**Planning (Listed Buildings and Conservation Areas) Act 1990 (as amended)  
Planning (Listed Buildings and Conservation Areas) Regulations 1990 (as amended)  
Application for Listed Building Consent for Alterations, Extension or Demolition of a Listed  
Building**

**Development**      Application for Listed Building Consent for conversion of existing listed building currently vacant to provide 4no flats. Demolition of single storey building at rear and construction of single storey extension and separate 2 storey building to provide 5no flats

**Location**          Manor House 12 Chichester Road Bognor Regis

EXISTING FLOOR PLANS

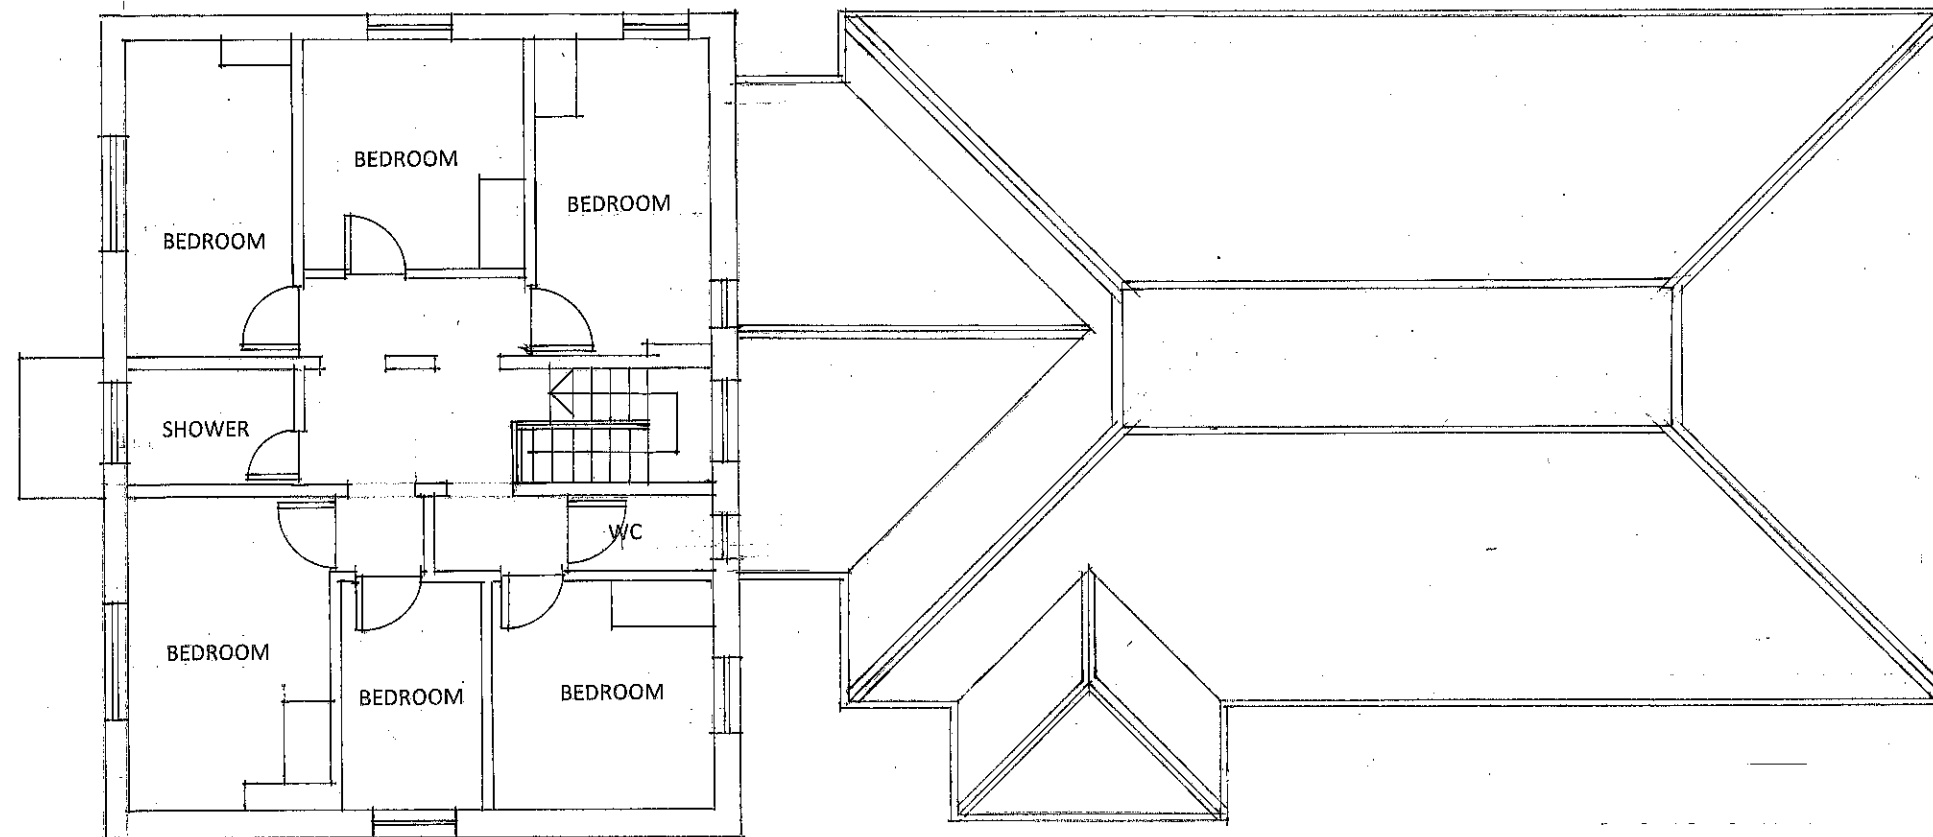
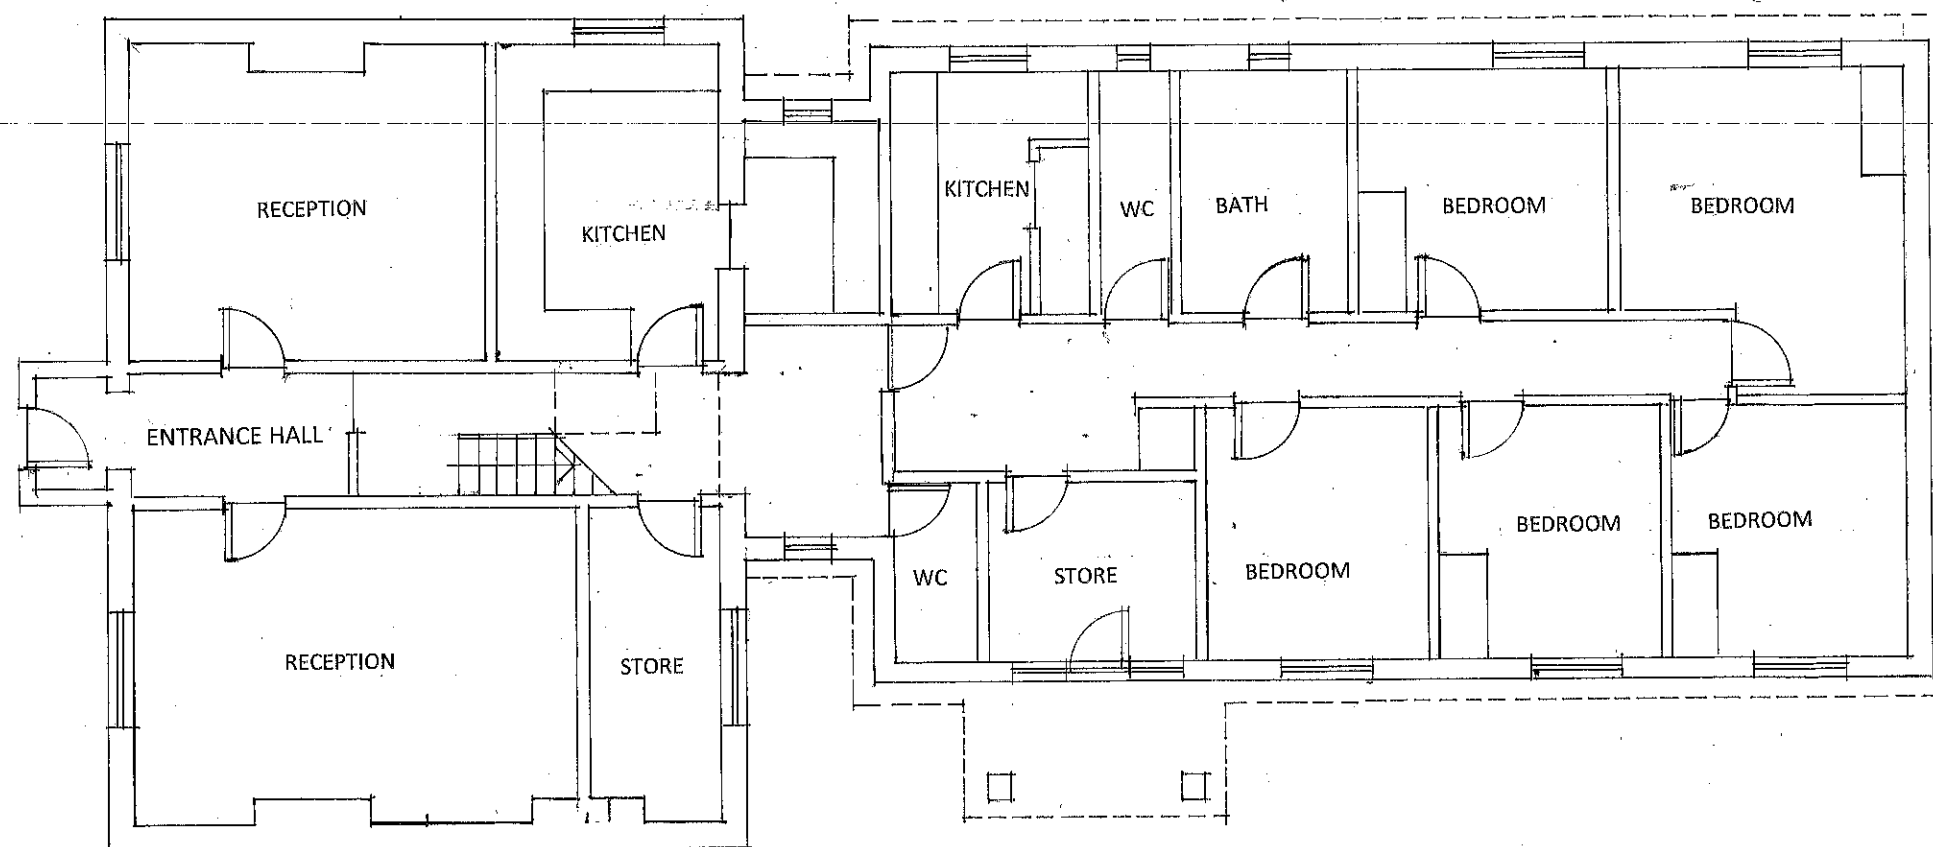
Floor Plans

Please submit 1 electronic or 3 paper copies of clearly labelled revised existing floor plans at a scale of 1:50 or 1:100, there appears to be a window missing from the North elevation. Further details can be found in the National Validation Requirements.

PROPOSED ELEVATIONS

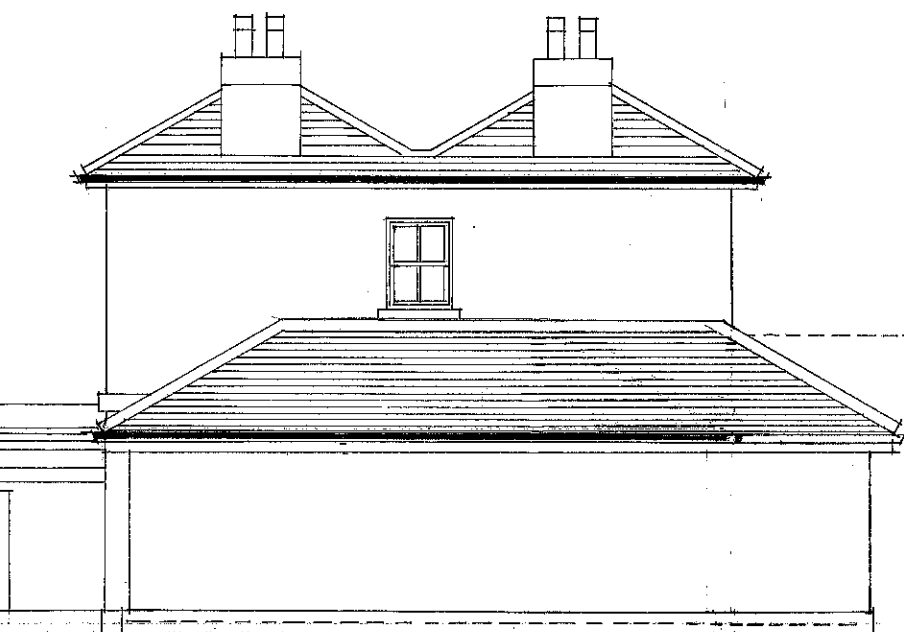
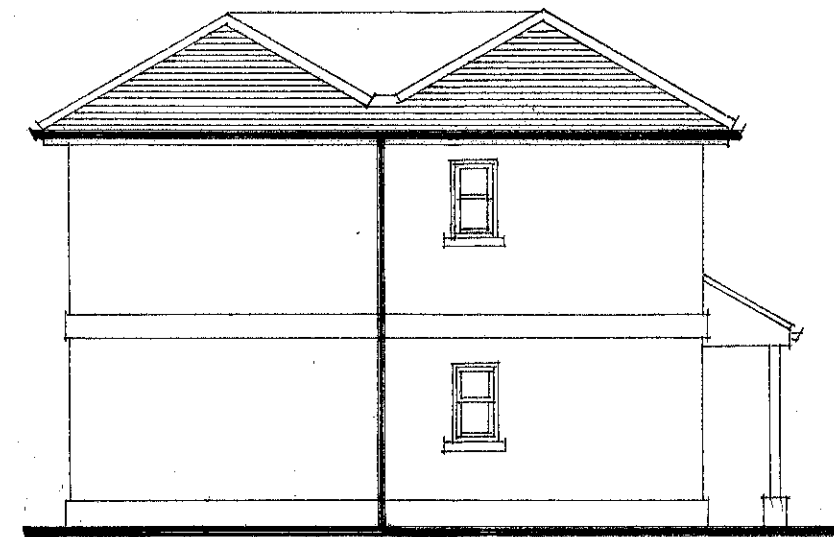
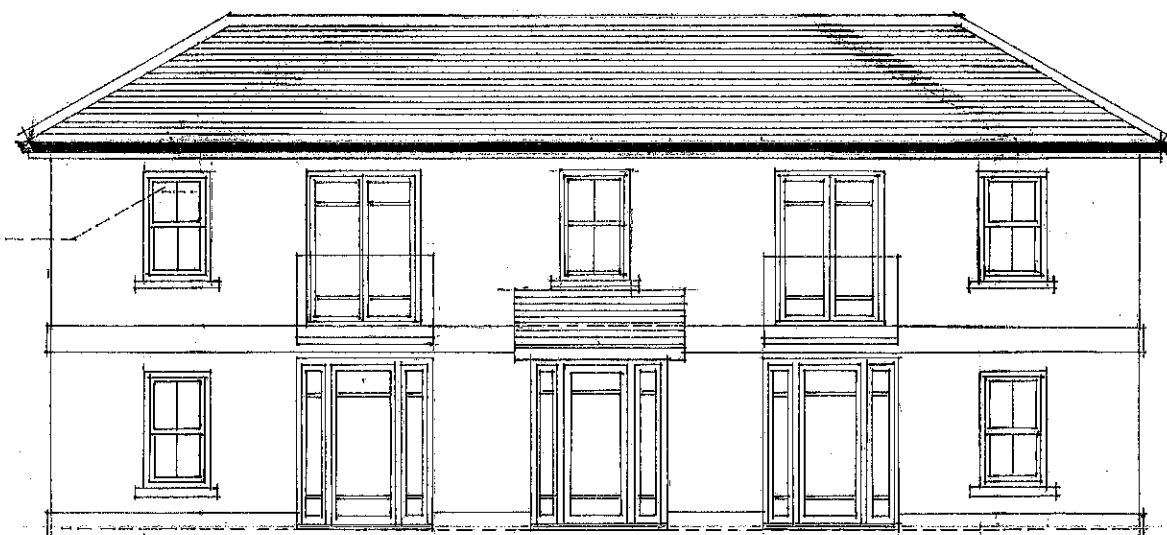
Elevations

Please submit 1 electronic or 3 paper copies of clearly labelled proposed South elevations of the Coach House at a scale of 1:50 or 1:100. Further details can be found in the National Validation Requirements.
